**WELWYN HATFIELD BOROUGH COUNCIL  
EXECUTIVE DIRECTOR - PLANNING, PUBLIC PROTECTION AND GOVERNANCE**

**Application No:** 6/2020/1344/FULL  
**Location:** Bell Bar Pet Farm, Bell Lane, Brookmans Park, Hatfield, AL9 7AY  
**Proposal:** Change of use of amenity land to residential driveway with new dropped kerb to highway  
**Officer:** Mr David Elmore

**Recommendation:** Refused

Drawing Name
Existing Site Location Plan + Photos

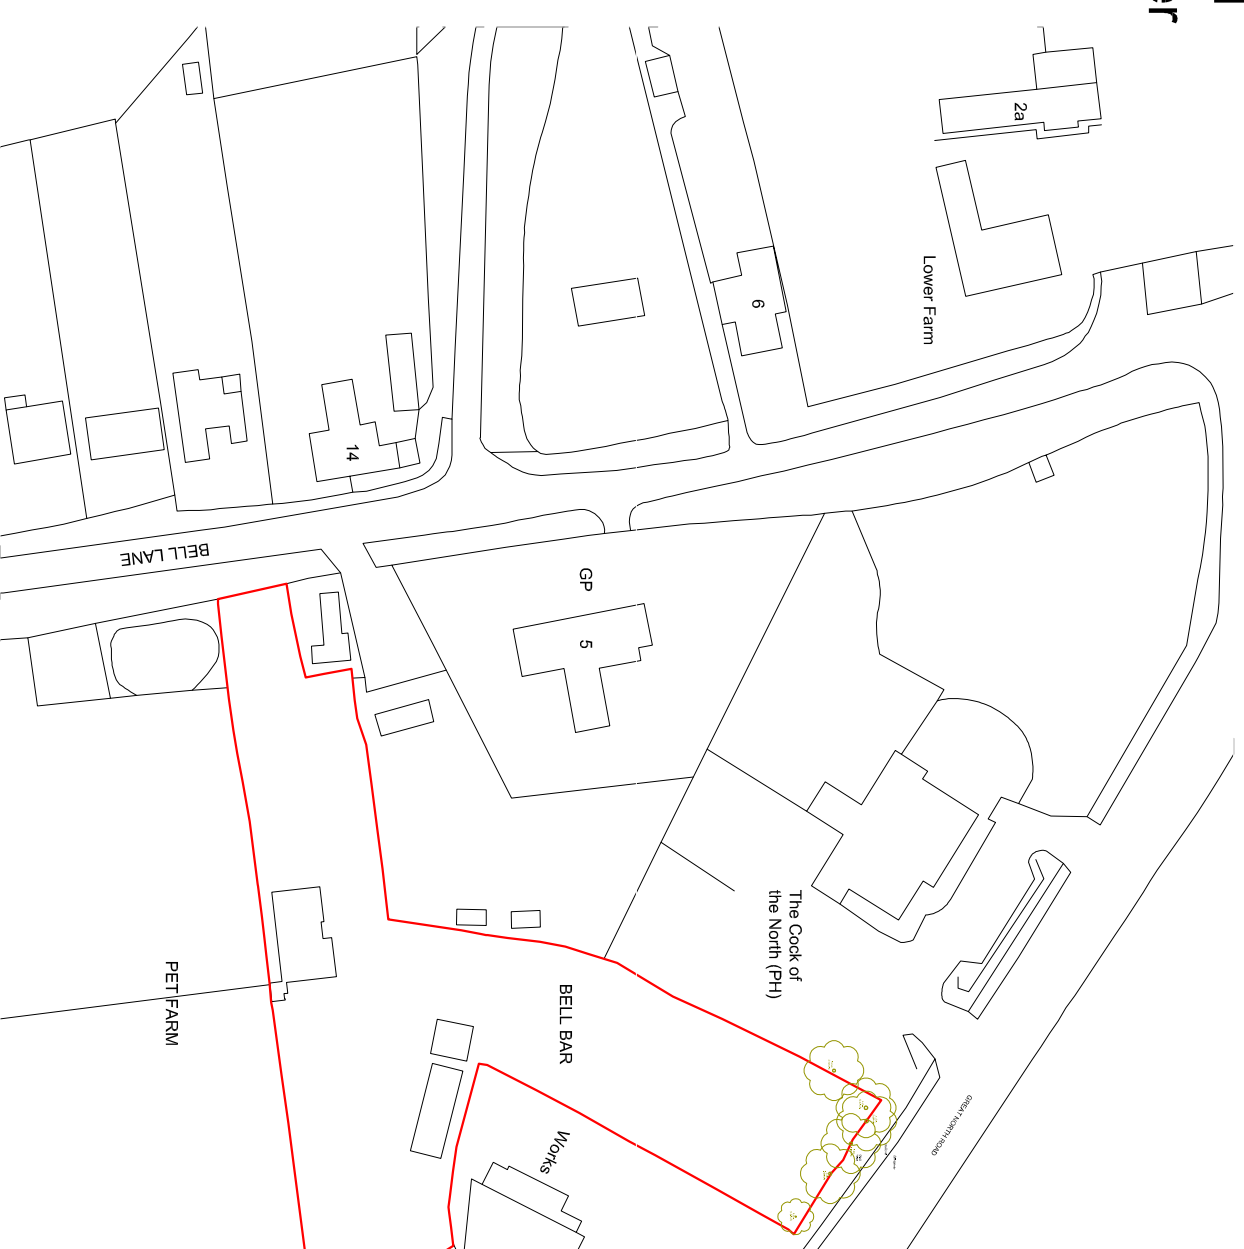
<p>The proposed crossover and dropped kerb are located outside the application site (edged in red). Consequently, this aspect of the proposal cannot be considered under this application. The extent of land that is proposed to change to residential is also not clear from the submitted plans and information.</p> <p>In terms of the proposed driveway, the proposed site plan annotates “flooring to be permeable (or porous) surfacing which allows water to drain through”.</p> <p>The replacement of grass to a permeable (or porous) floored surface over such an area would be in stark contrast to the character and appearance of the site and its area. Harm to the area would result in conflict with the above policies. Whilst the sites either side are predominately hard surfaced, they do include long established commercial buildings and therefore do not draw direct comparisons to the application proposal.</p> <p>The frontage of the undeveloped land (fronting the A1000) is lined with trees and so too are the side boundaries. These trees are considered to contribute to the landscape quality of the area, particularly when passing along the Great North Road. Local Plan Policy R17 seeks to protect existing trees whilst Policy D8 requires landscaping to form an integral part of the overall design, and in this respect the high quality design required by Policy D1 and D2 would again be relevant. Policy RA10 considers the impact of development on the landscape character area.</p> <p>No information has been submitted to demonstrate how these trees will be protected from the proposed development. Therefore, it cannot be reasonably concluded that the proposal would not harm these trees and maintain area’s character.</p>

<b>Conclusion</b>	
<p>The proposed crossover and dropped kerb are located outside the application site (edged in red). Consequently, this aspect of the proposal cannot be considered under this application.</p> <p>The change of use of the undeveloped land to a residential driveway and the associated laying of a driveway across its whole area would result in a material loss of Green Belt openness. This aspect of the proposal would therefore represent inappropriate development in the Green Belt in conflict with Policy GBSP1 of the Welwyn Hatfield District Plan 2005 and the National Planning Policy Framework.</p> <p>The laying of a driveway across the area of undeveloped land would be in stark contrast to the character and appearance of the site and its area. Furthermore, no information has been submitted in terms of the impact of the proposed driveway on existing trees. Therefore, it cannot be reasonably concluded that the area's landscape character would be maintained as a result. Consequently, the proposal would conflict with Policies D1, D2, D8, R17 and RA10 of the Welwyn Hatfield District Plan 2005, Supplementary Design Guidance 2005 and the National Planning Policy Framework.</p>
